ENG-PUDSP21010-R3-GEC.pdf Markup Summary

Subject: Callout
Page Index: 6
Date: 4/18/2022 4:40:08 PM
Author: dsdrice
Color: ■
Layer:
Space:
Page Label: [6] 6 GRADING & EROSION CONTROL PLAN

G2.5

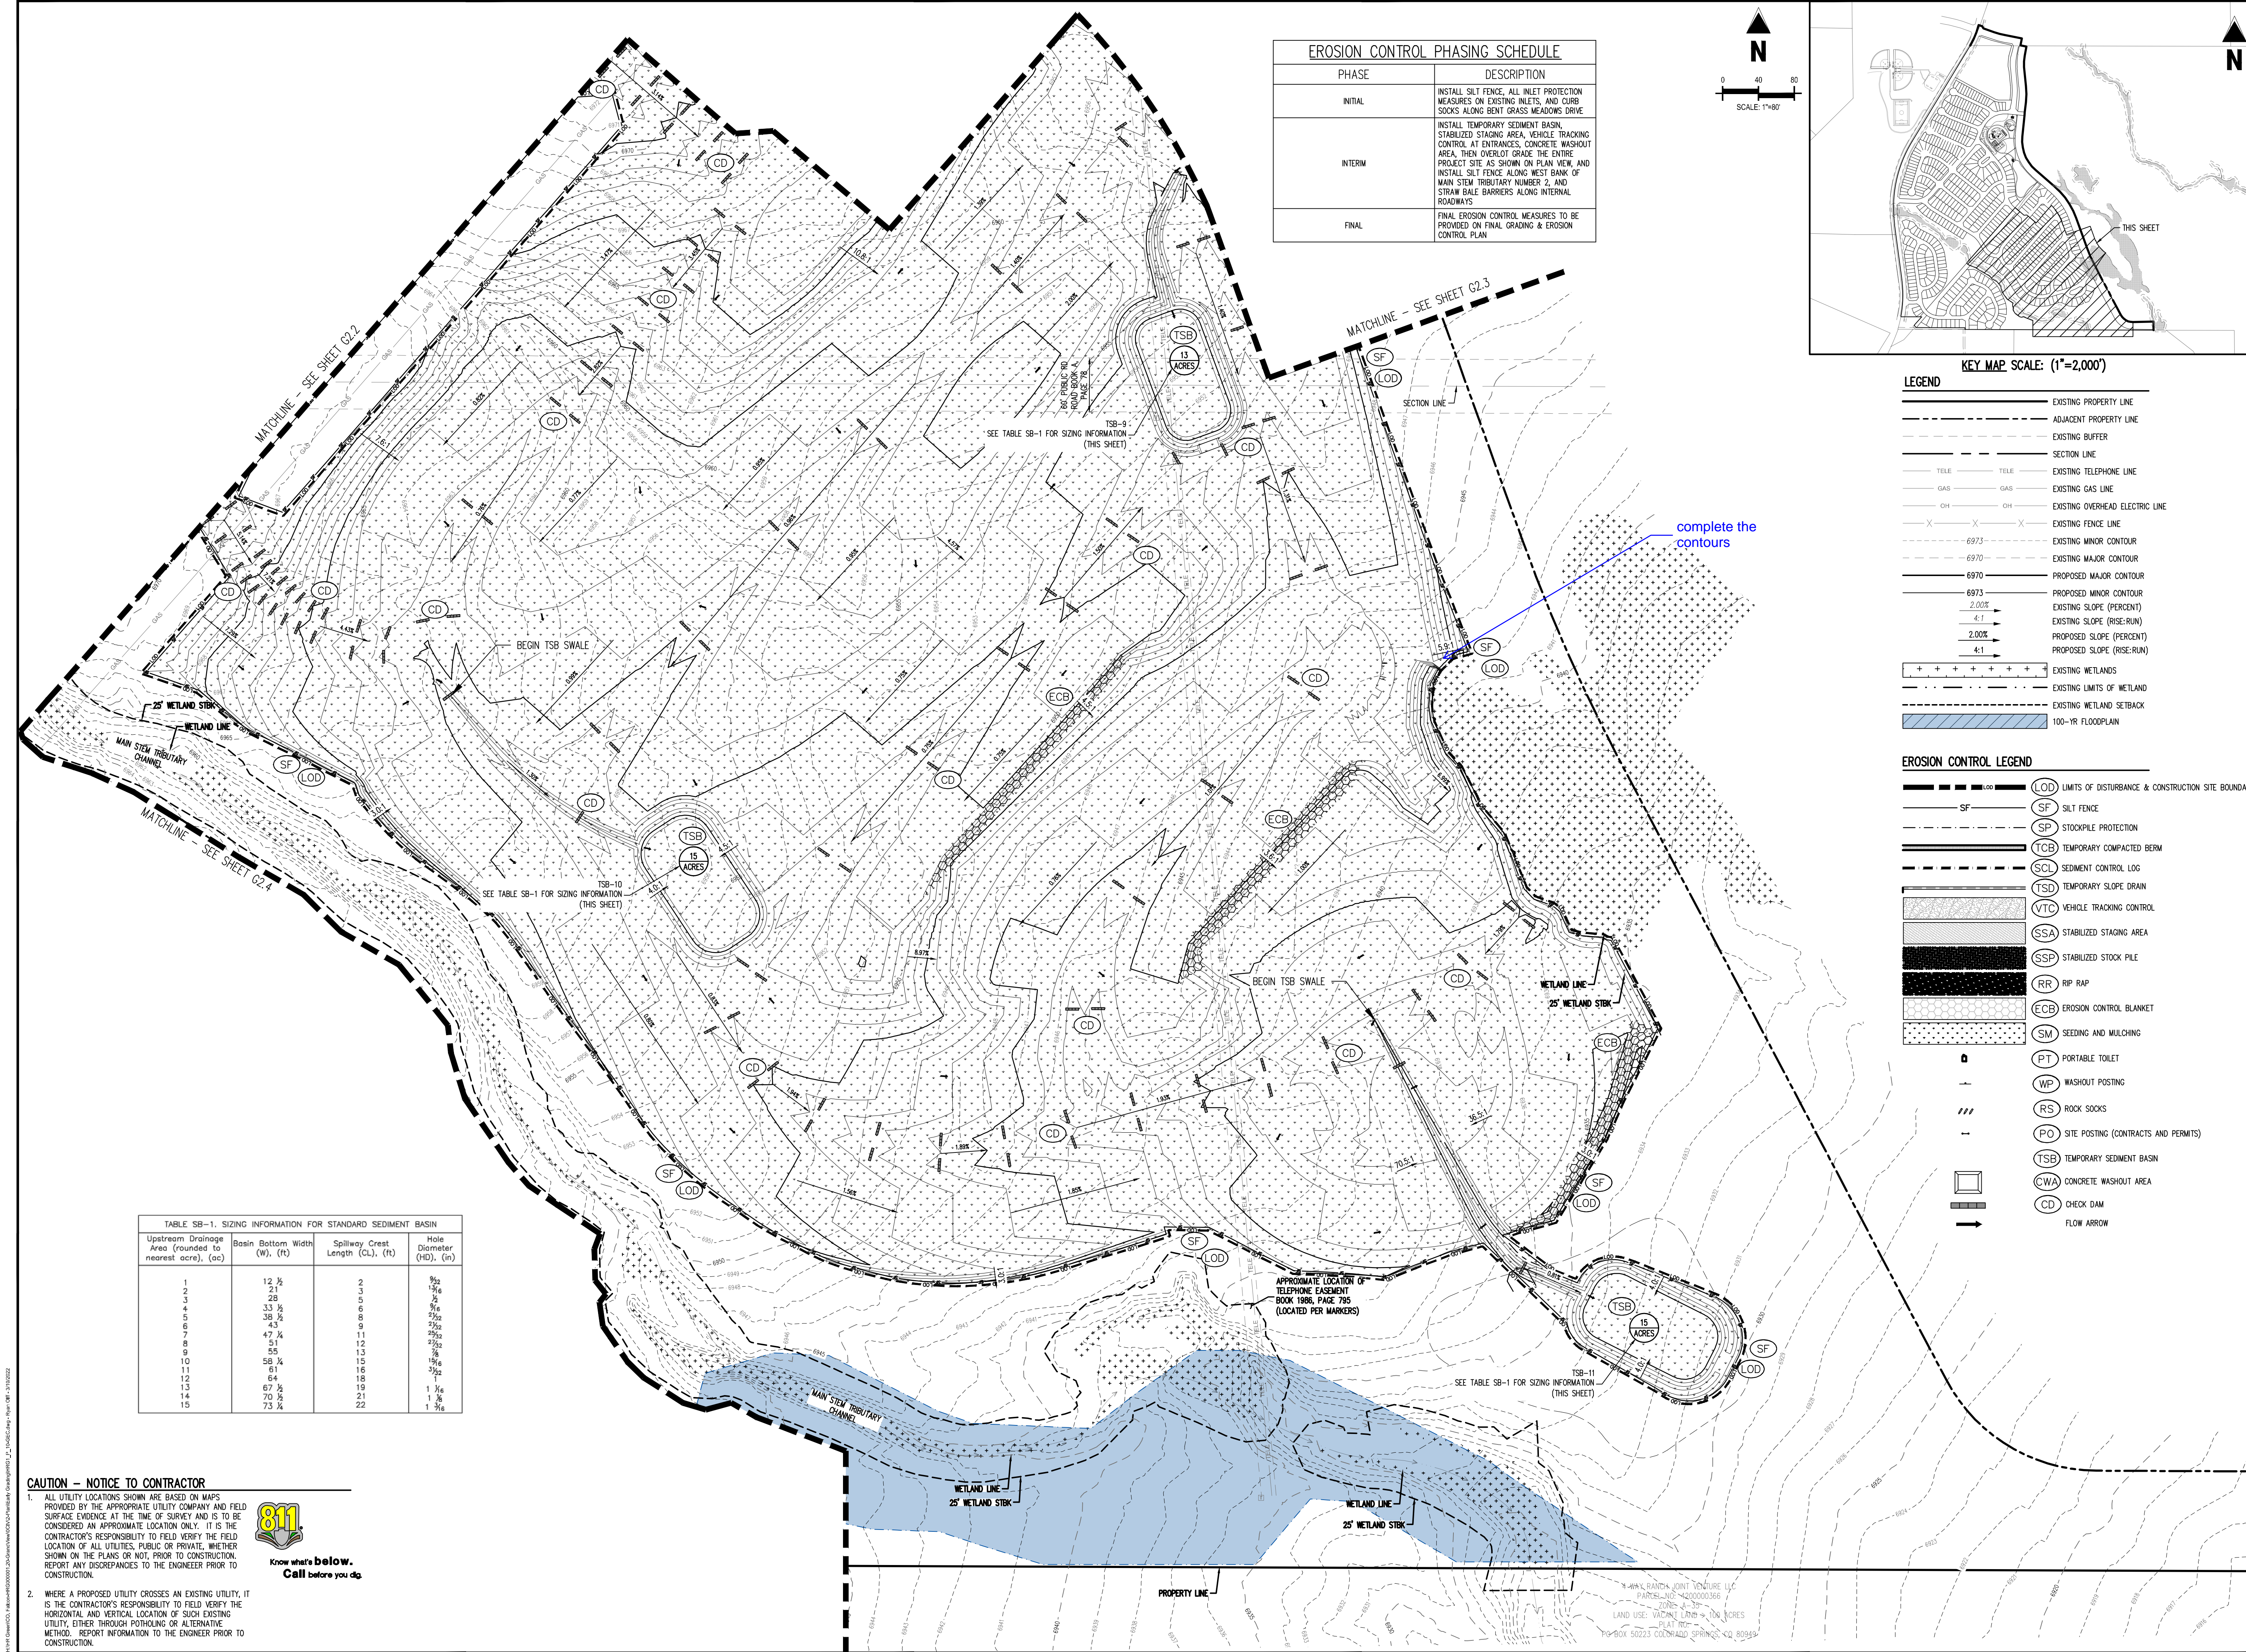
complete the contours

G2.1

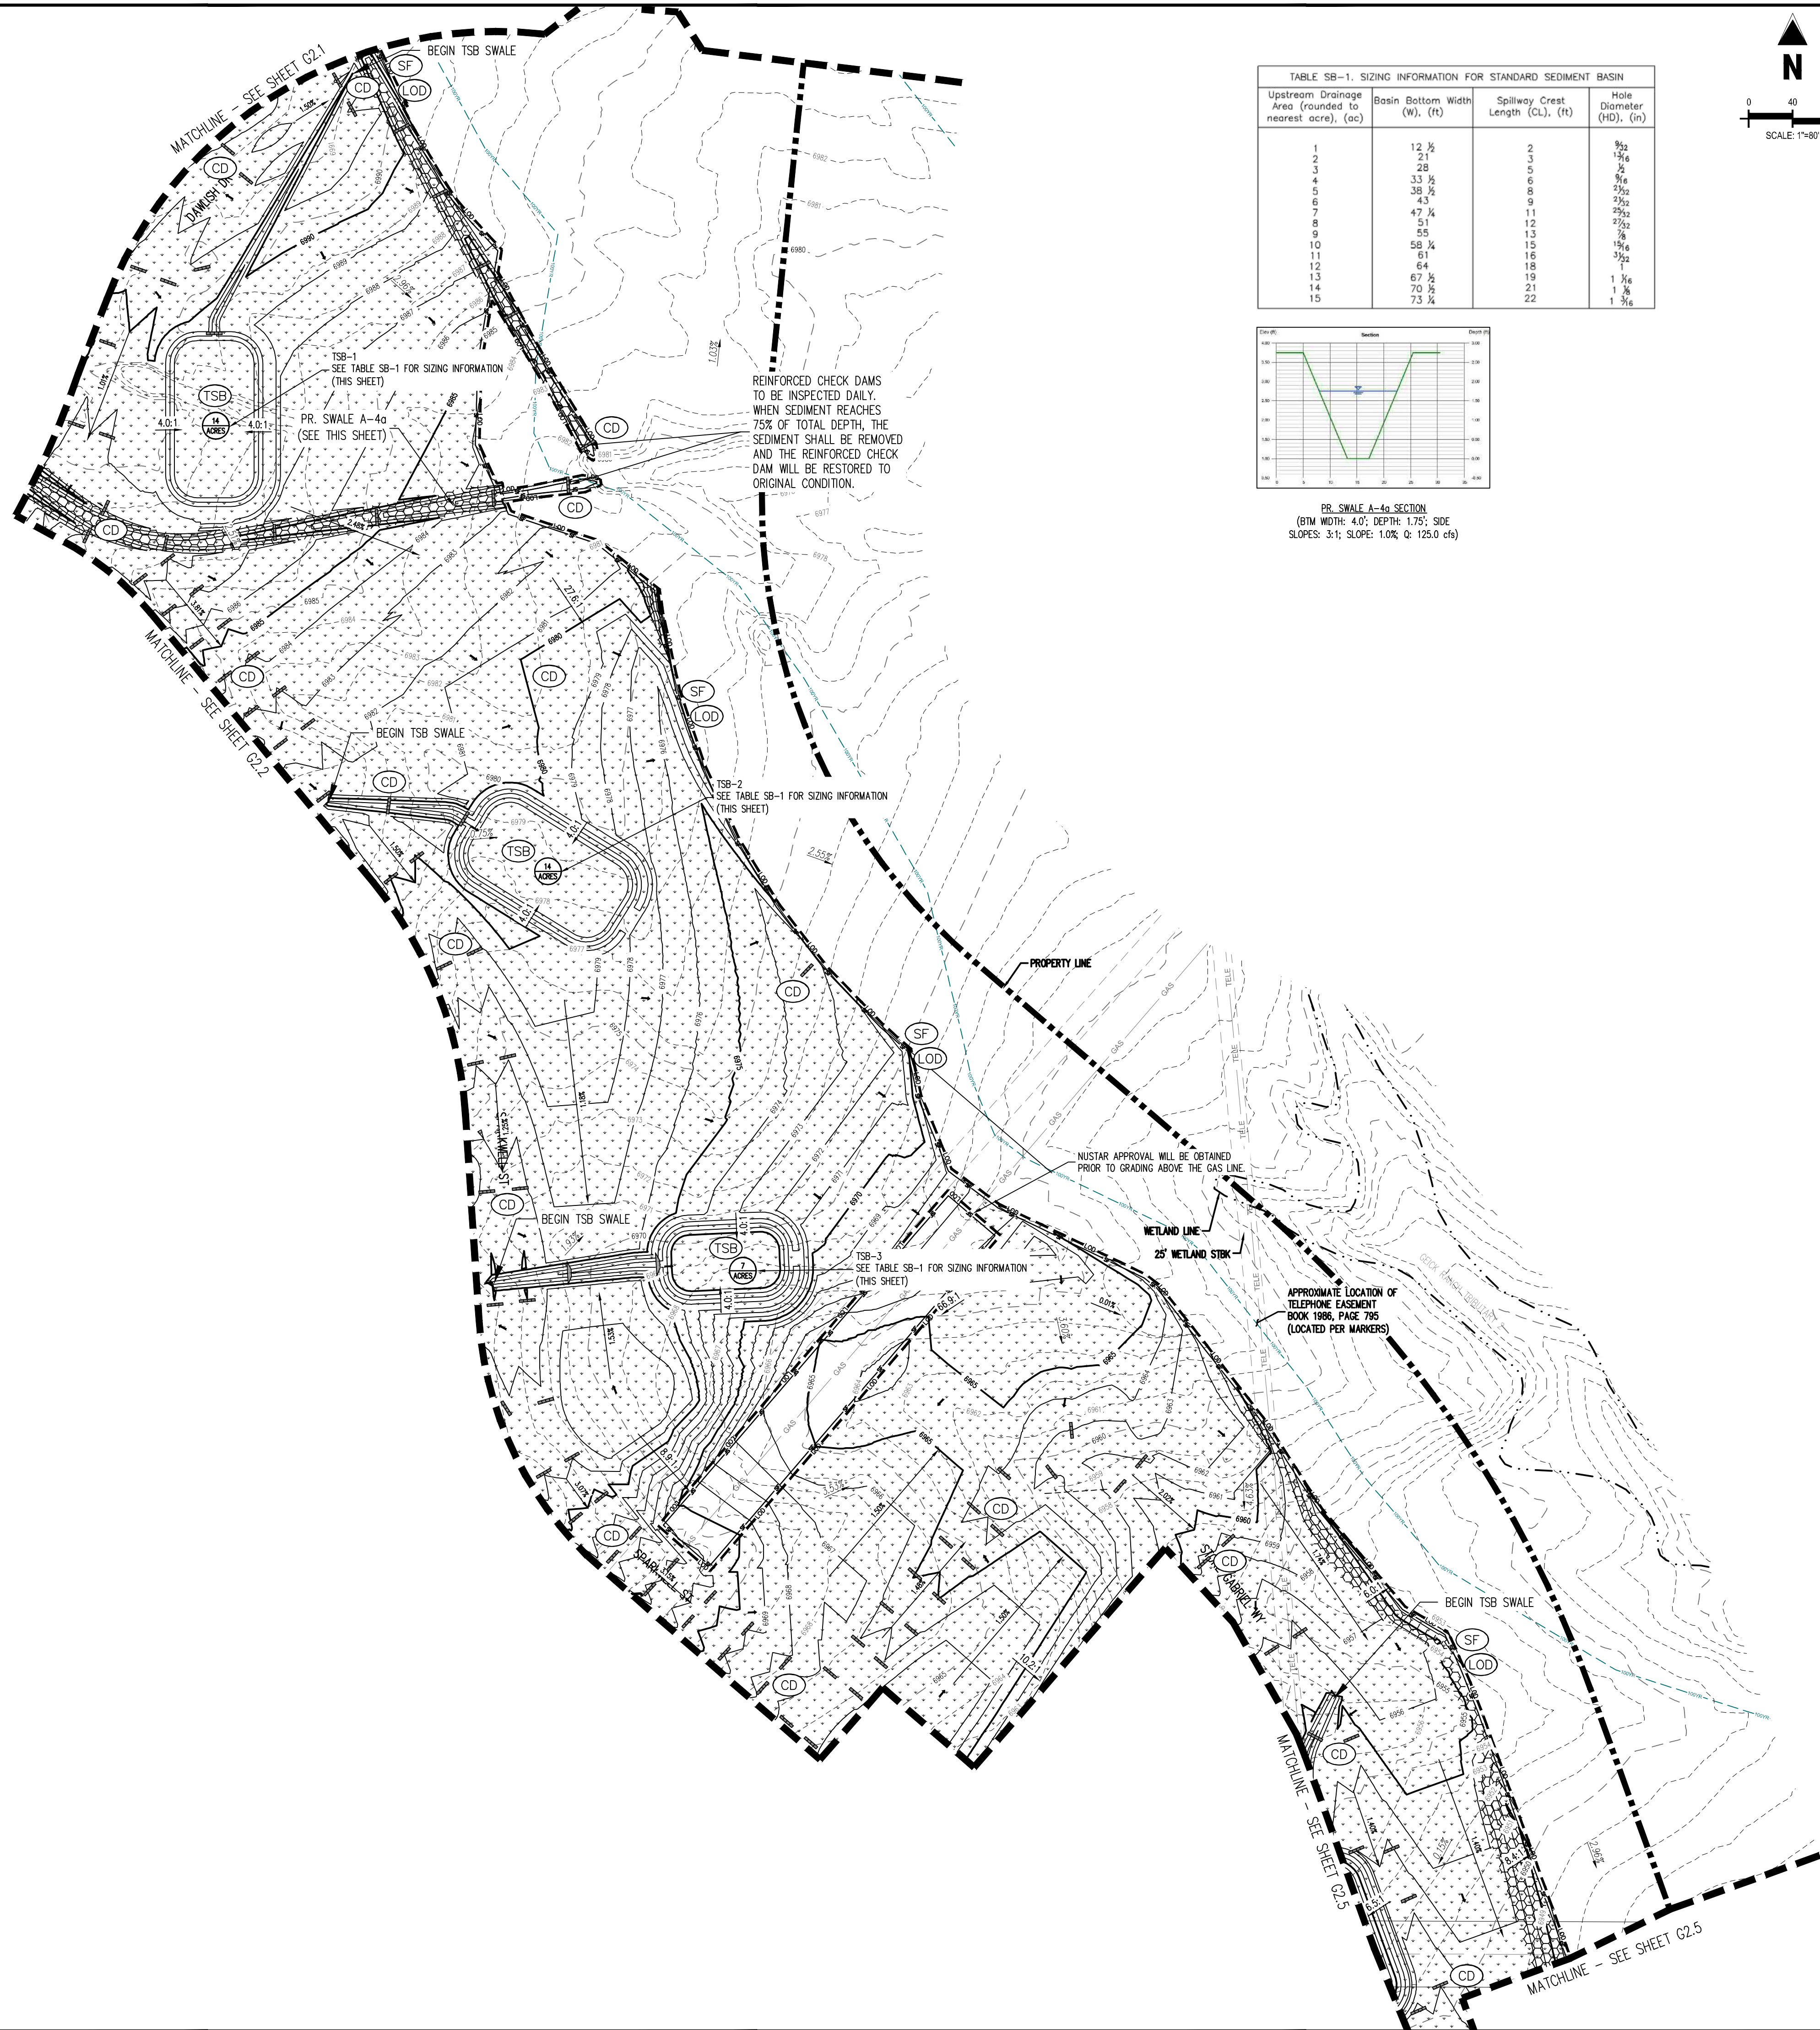
it appears that interim stabilization or BMP may be needed here for the contributing area.

Show how the offsite flow will be conveyed
